Access Review

University of Wollongong
Molecular & Life Sciences Building
Issue 3
31/03/17

DDA Access Diagram

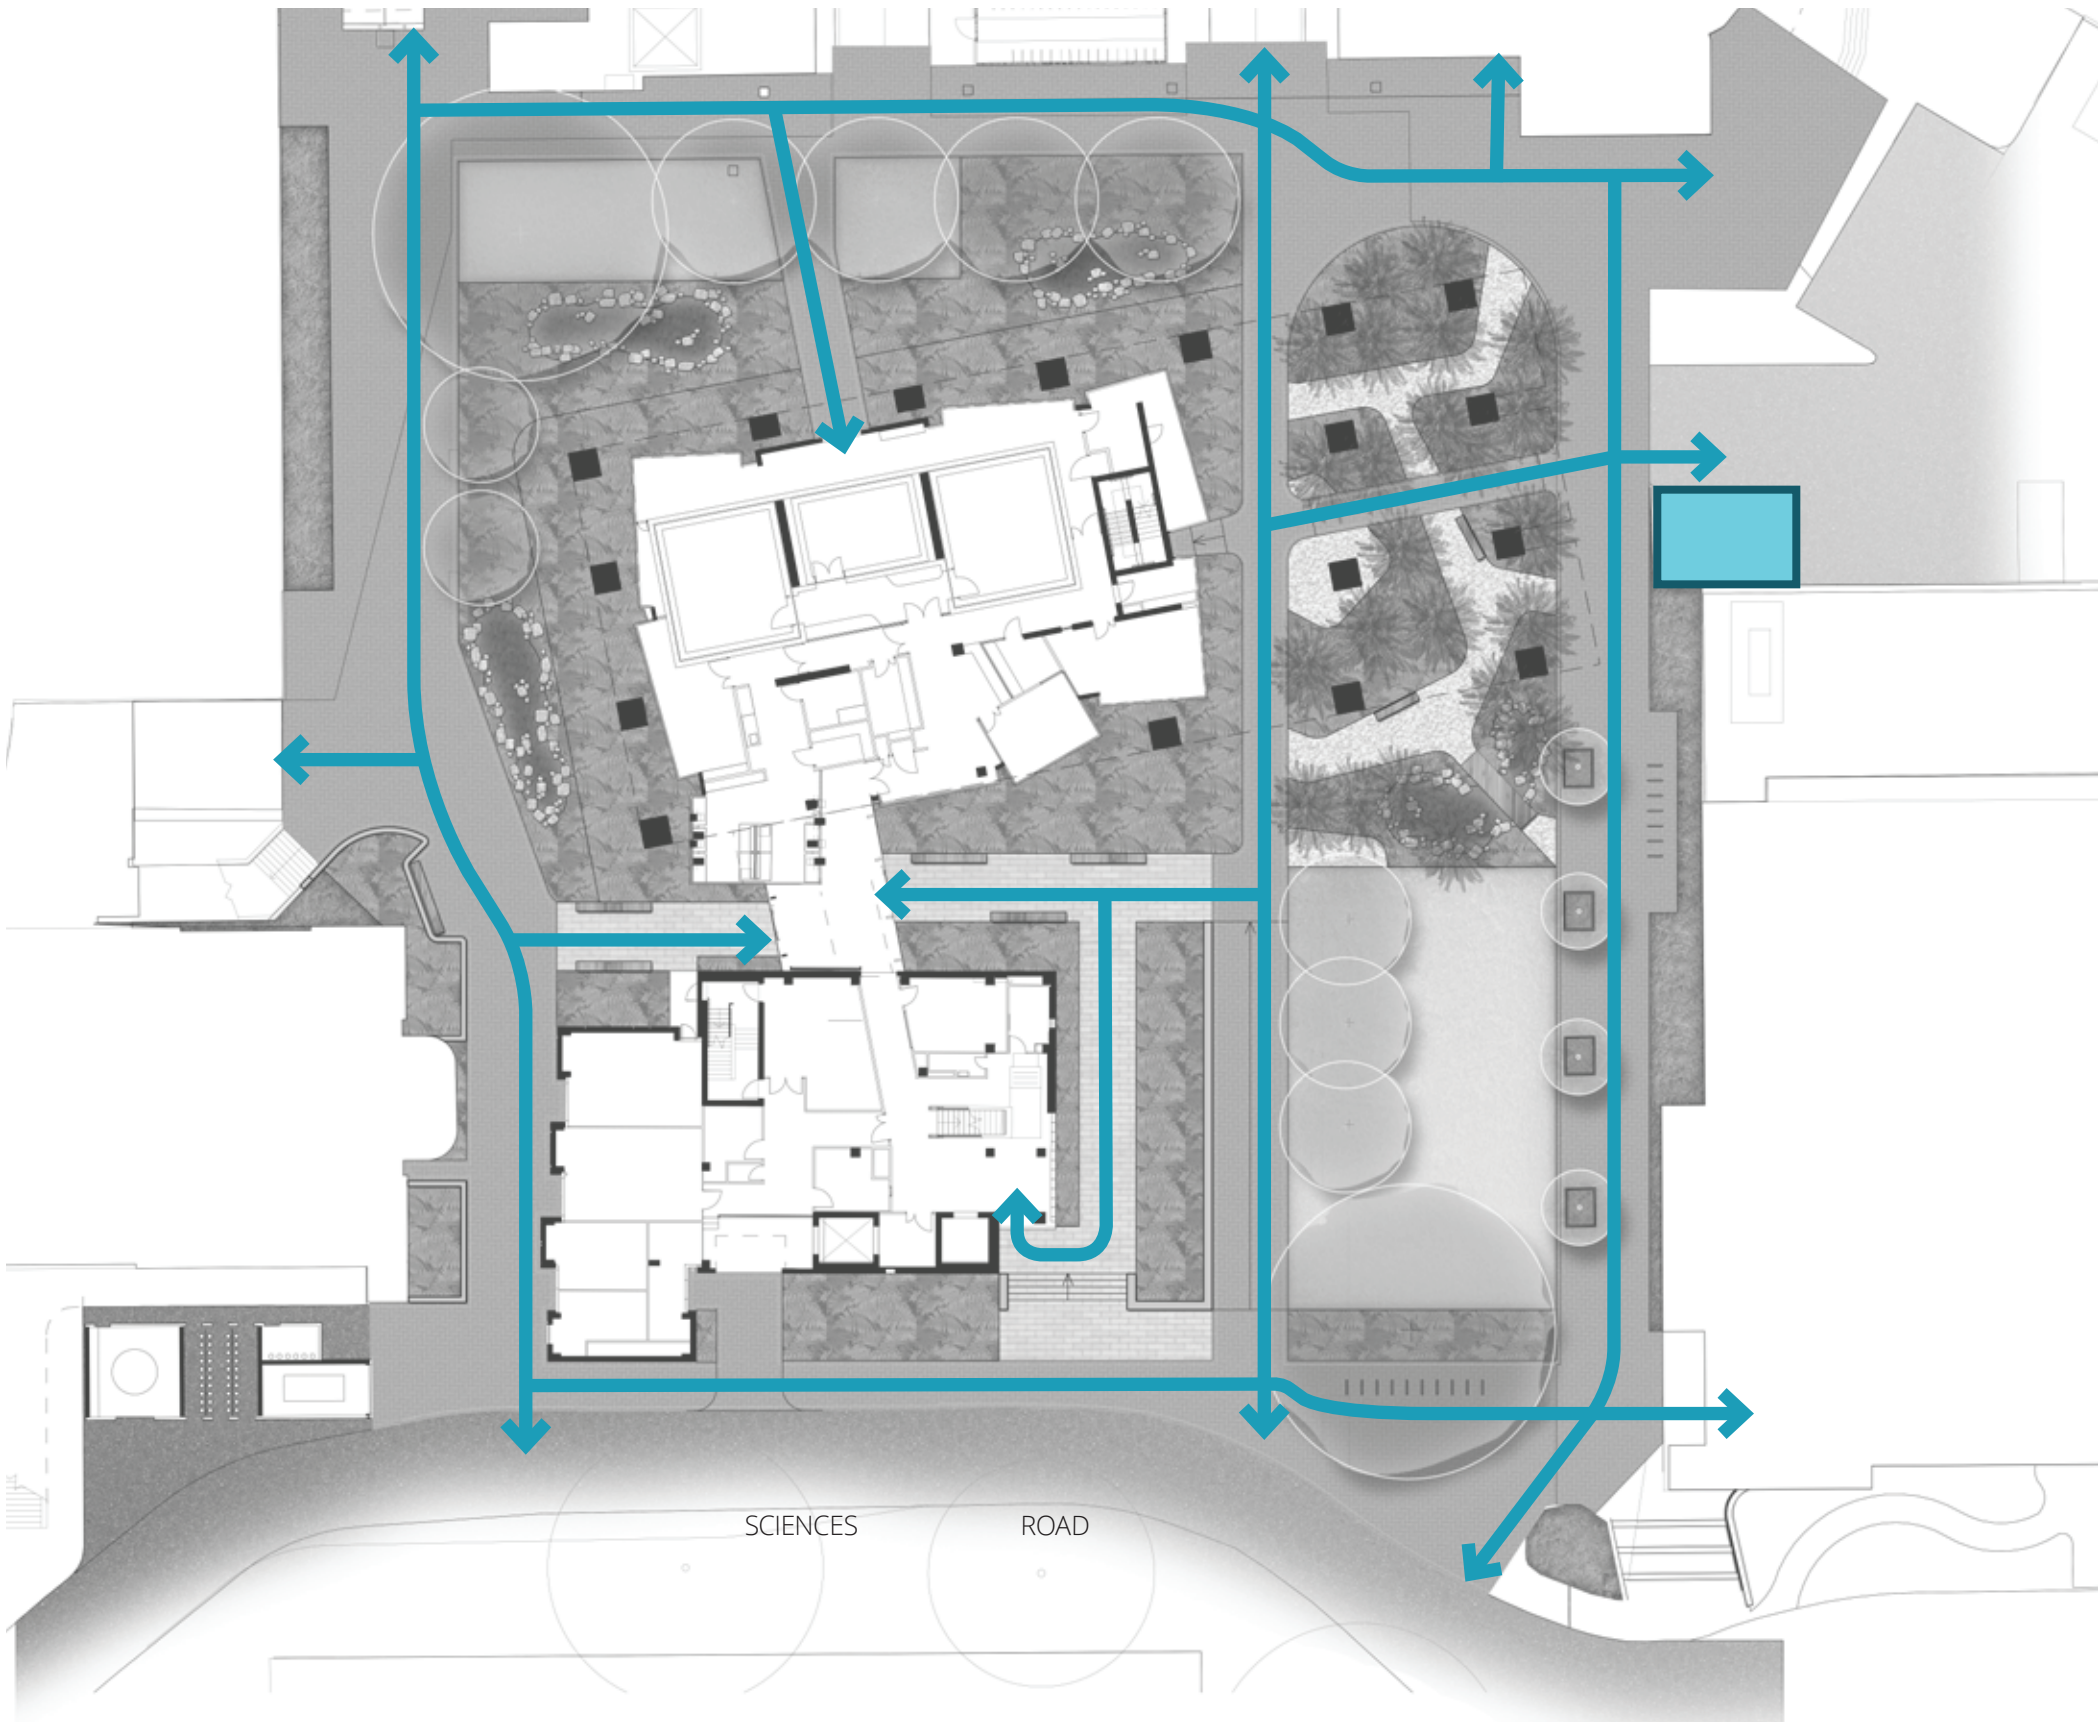
- A primary pedestrian link from the south to the principal entrance via a 1:27 path
- A primary pedestrian link from the north that also links to the adjacent IHMRI building
- A 1:28 pedestrian link from the accessible car parking to the principal pedestrian entrance through the proposed rainforest planting
- A primary pedestrian link from the northwest to the central atrium entrance
- A pedestrian bridge linking the adjacent IHMRI building

- i. The designated accessible parking spaces to include dimensions and a layout to meet the requirements of AS2890.6 (2009) and identification signage. This includes a dedicated (non-shared) space with dimensions 2.4m wide x 5.4m long; a shared area on one side of the dedicated space 2.4m wide x 5.4m long; a shared area at the end of each space 2.4m x 2.4m and a 1200mm high bollard located in the centre and 800mm from the front edge of the shared space.
- ii. Parking space related walking and wheelchair unloading areas comprise a slip-resistant, firm plane surface with a fall not exceeding 1:40 in any direction or 1:33 if the surface is a bituminous seal.
